5 December 2017

Ref: A19366950

Re: NorthConnex (SSI 13_6136) – Modification request – Correction and clarification of ventilation outlet elevations

MOTORWAY OPERATIONS COMPLEX - SOUTHERN VENTILATION FACILITY - SECTIONS
M1-M2-5000-DR-JD-0525

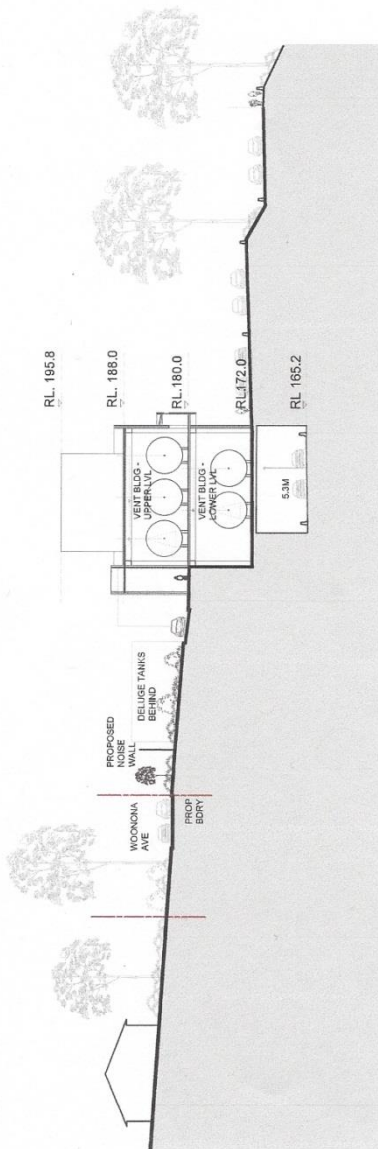
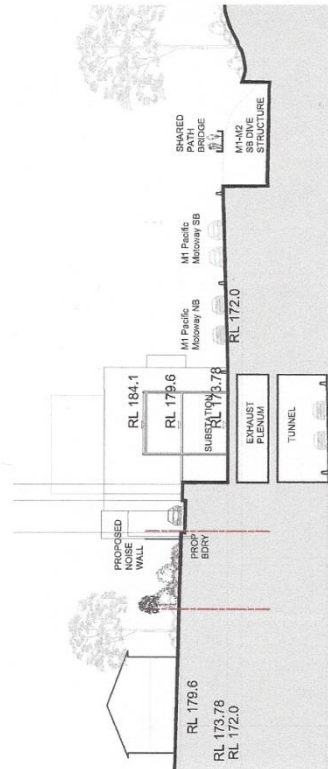
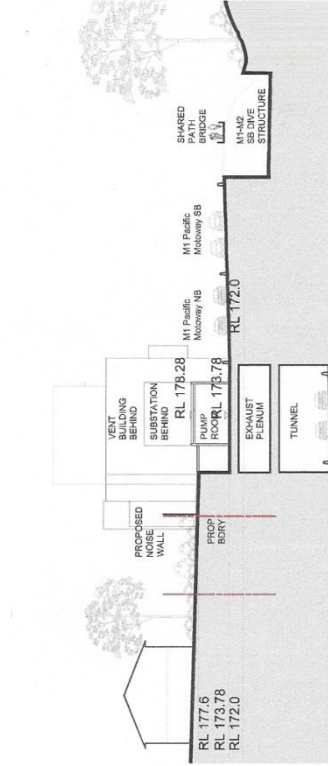
- (a) the northern ventilation outlet tip height: ~~194~~ 200.8 metres (AHD); and*
- (b) the southern ventilation outlet tip height: ~~147~~ 148 metres (AHD).*

- 28.8 metres for the northern ventilation outlet; and
- 29.5 metres for the southern ventilation outlet.

This difference is because the total physical ventilation outlet structure extends below both Woonona Avenue and Gum Grove Place.

The two components of the modification requested by Roads and Maritime could be achieved through amendment of condition B2 to reflect the base height and tip height for the two ventilation outlets as specified for the Amended design in **Table 1**.

M1-M2-5000-DR-UD-0550
NORTHERN VENTILATION FACILITY - CROSS SECTIONS

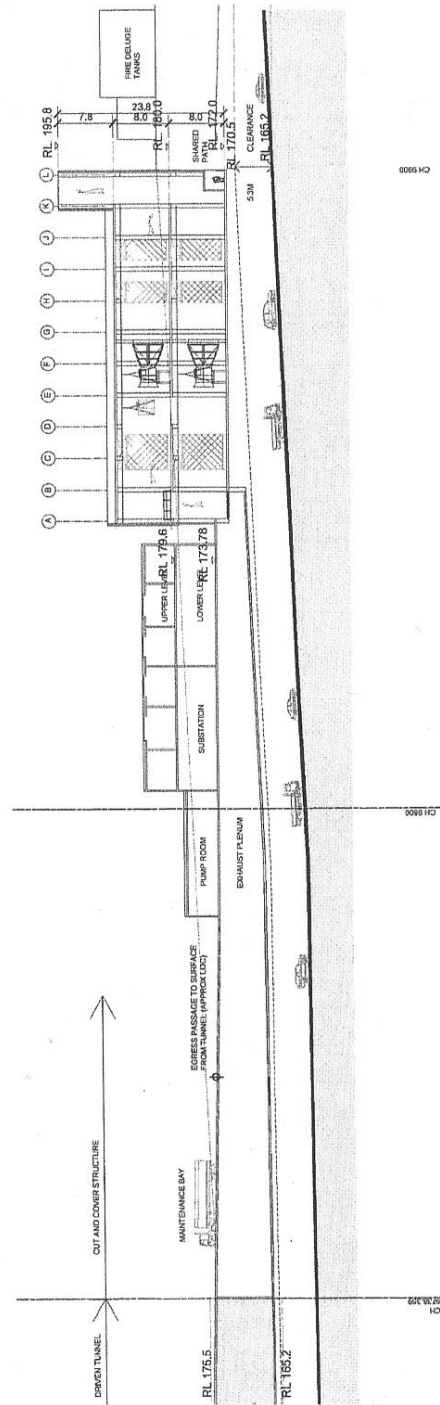
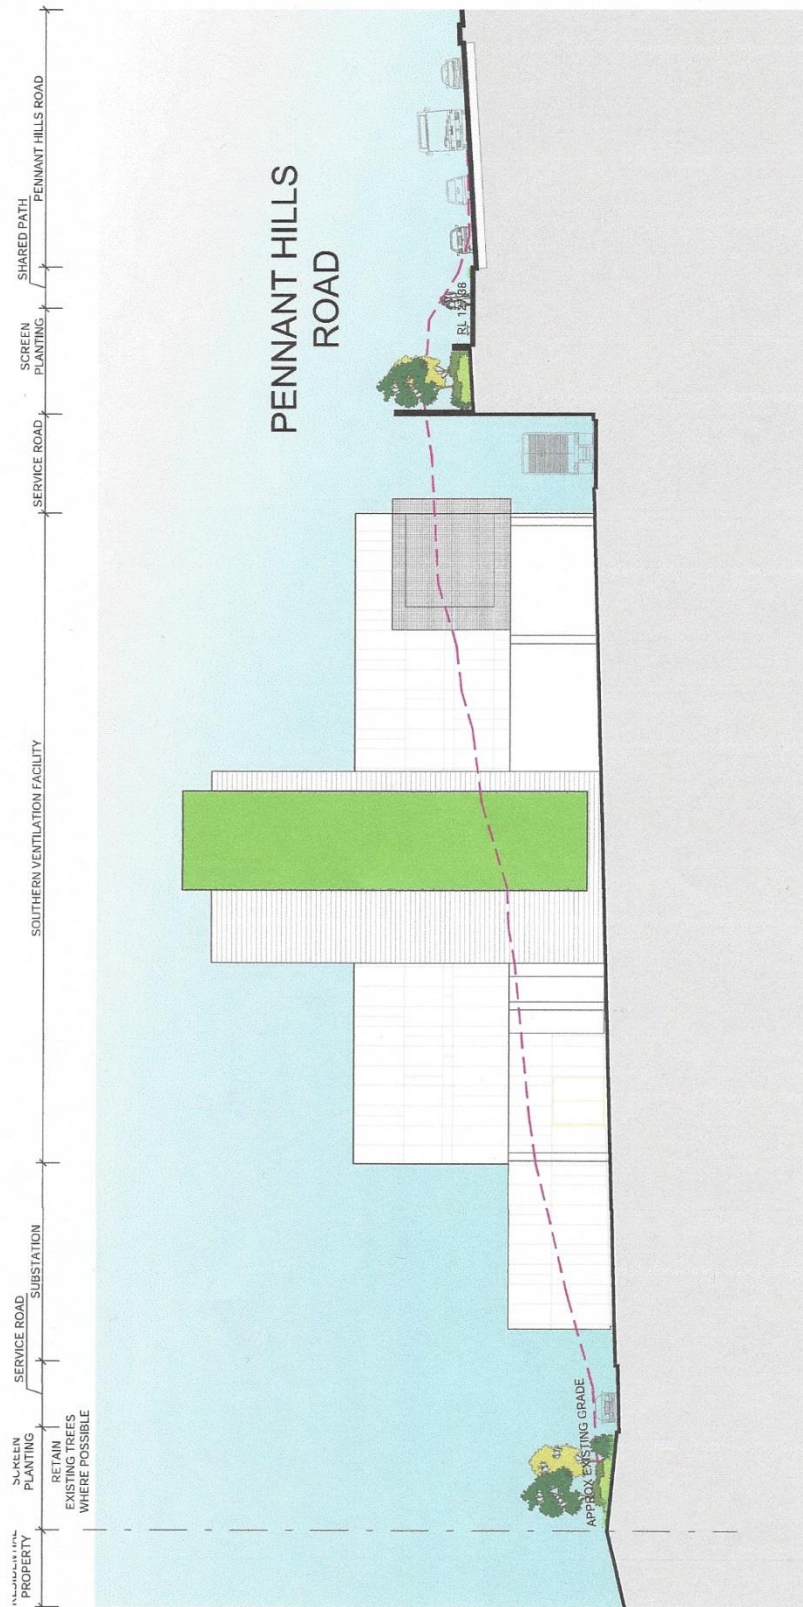
B2 The ventilation outlets shall be constructed to achieve an outlet exit plane at a height of 20 metres above ground level. The ventilation outlets shall be constructed at an approximate height of:

- Correction of the tip height of both the northern ventilation outlet and the southern ventilation outlet; and
- Clarification of the reference point for measuring the specified 20 metre height of each ventilation outlet.

For simplicity, ventilation outlet heights included in the Environmental Impact Statement (15 metre ventilation outlets) for the project and the subsequent Submissions and Preferred Infrastructure Report (20 metre ventilation outlets) were quoted relative to the nearest adjacent local road. The nearest adjacent road is Woonona Avenue in the case of the northern ventilation outlet, and Gum Grove Place in the case of the southern ventilation outlet.

As can be seen from **Table 1**, the total physical height of each ventilation outlet for the Amended Design is:
